WEST SUSSEX COUNTY COUNCIL CONSULTATION

TO:	Arun District Council FAO: James Cross
FROM:	WSCC - Highway Authority
DATE:	23 November 2021
LOCATION:	Ryefields Farmhouse Oak Tree Lane Chichester PO20 3GU
SUBJECT:	AL/126/21/PL Demolition of existing building and erection of 5 No houses comprising 1 No 4-bed detached, 2 No 4-bed link detached & 2 No 3-bed detached houses with associated access & parking (re-submission of AL/81/21/PL). This site falls within Strategic Site SD5, CIL Zone 1 (Zero Rated.
DATE OF SITE VISIT:	n/a (undertaken for earlier submission on the site – AL/72/19/PL)
RECOMMENDATION:	Advice
S106 CONTRIBUTION TOTAL:	£ See below for breakdown.

Figure 1.3: Proposed Site Layout

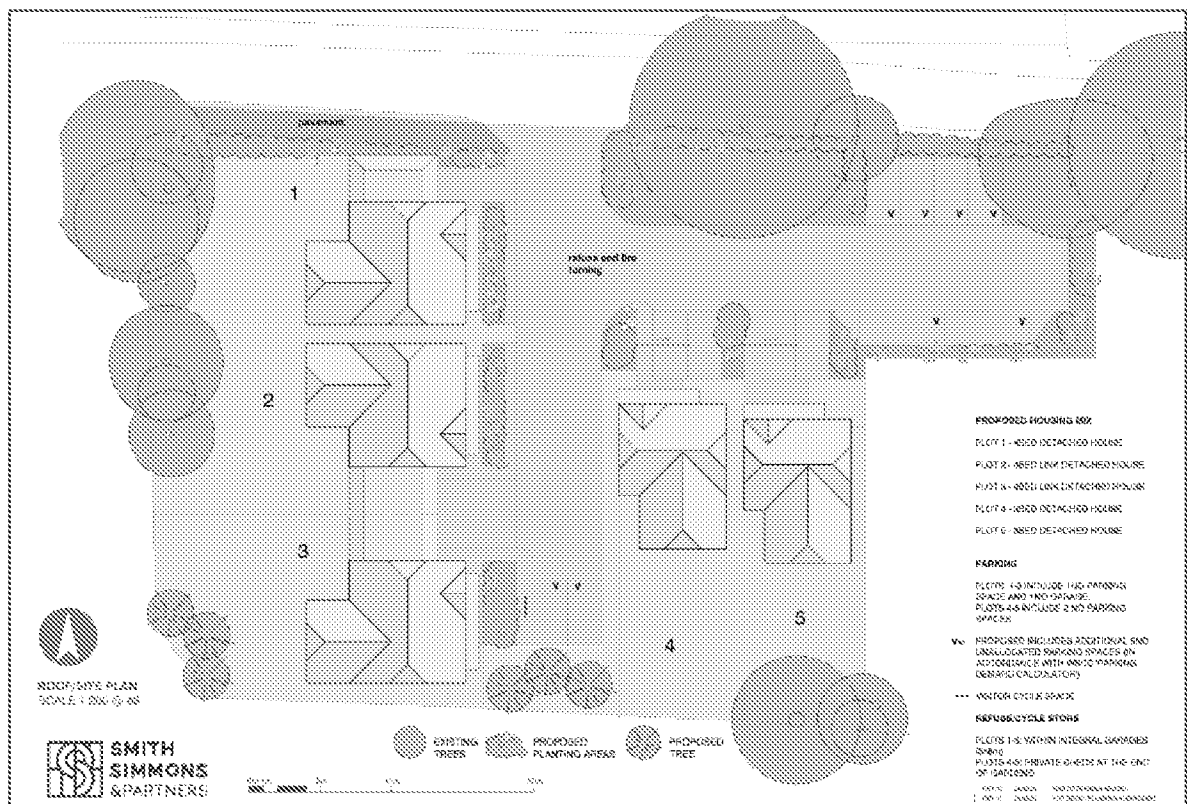
The applicant proposes 5 dwellings. The access is shown approximately 20m east of the end of the residential part of the road. At this point, Oak Tree Lane narrows-down with no footways and is more rural in nature with hedgrows on the northern side and planting/foliage on the southern (site) side. The access is shown measuring approximately 6.0m wide with bellmouth radii both sides. This is then shown leading to an access measuring approximately 5.5m wide. Three of the houses are found to the west of the internal access 'road' and the remaining two to the east. A turning head is shown approximately 6m into the site. Parking is shown in front of all the plots with visitor parking shown mainly along part of the northern part of the site and two spaces shown to the south of the site. Parking for cycles is referred to as being in the gardens

The submitted drawings show a 2.0m-wide footway being extended from Oak Tree Close up to the site.

No part of the development shall be first occupied until such time as the vehicular access, new footway and internal access road serving the development has been constructed in accordance with the details shown on the approved drawing.

MBSK211029-1

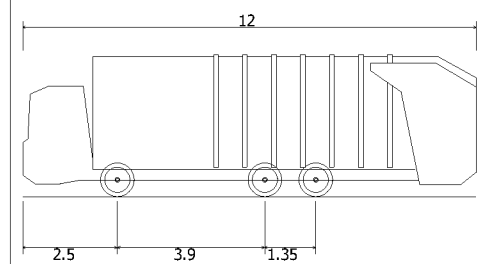
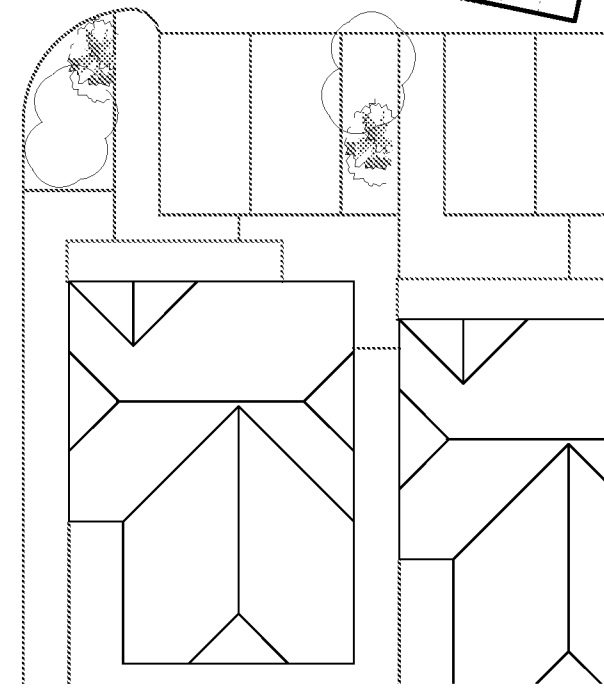
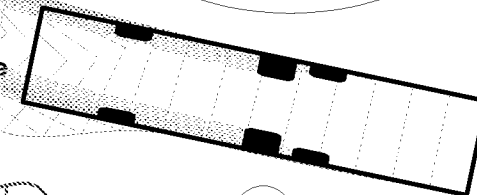
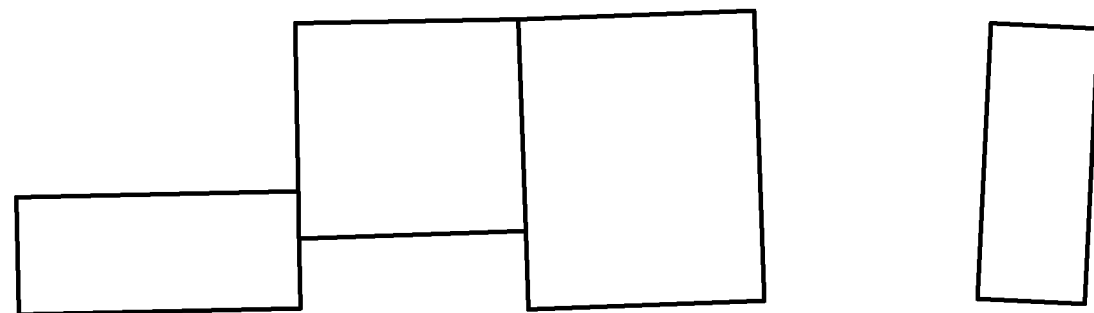
Further to this, visibility splays are shown at the access point where it joins Oak Tree Lane. Also, swept-path diagrams showing a 12m-long refuse vehicle turning within the site have been provided which demonstrate that both refuse and fire appliances can enter and leave the site and turn within it (a fire appliance is shorter than a refuse vehicle so should be able to turn within the space provided). The swept-path diagrams also demonstrate that such vehicles would be able to negotiate the access itself.
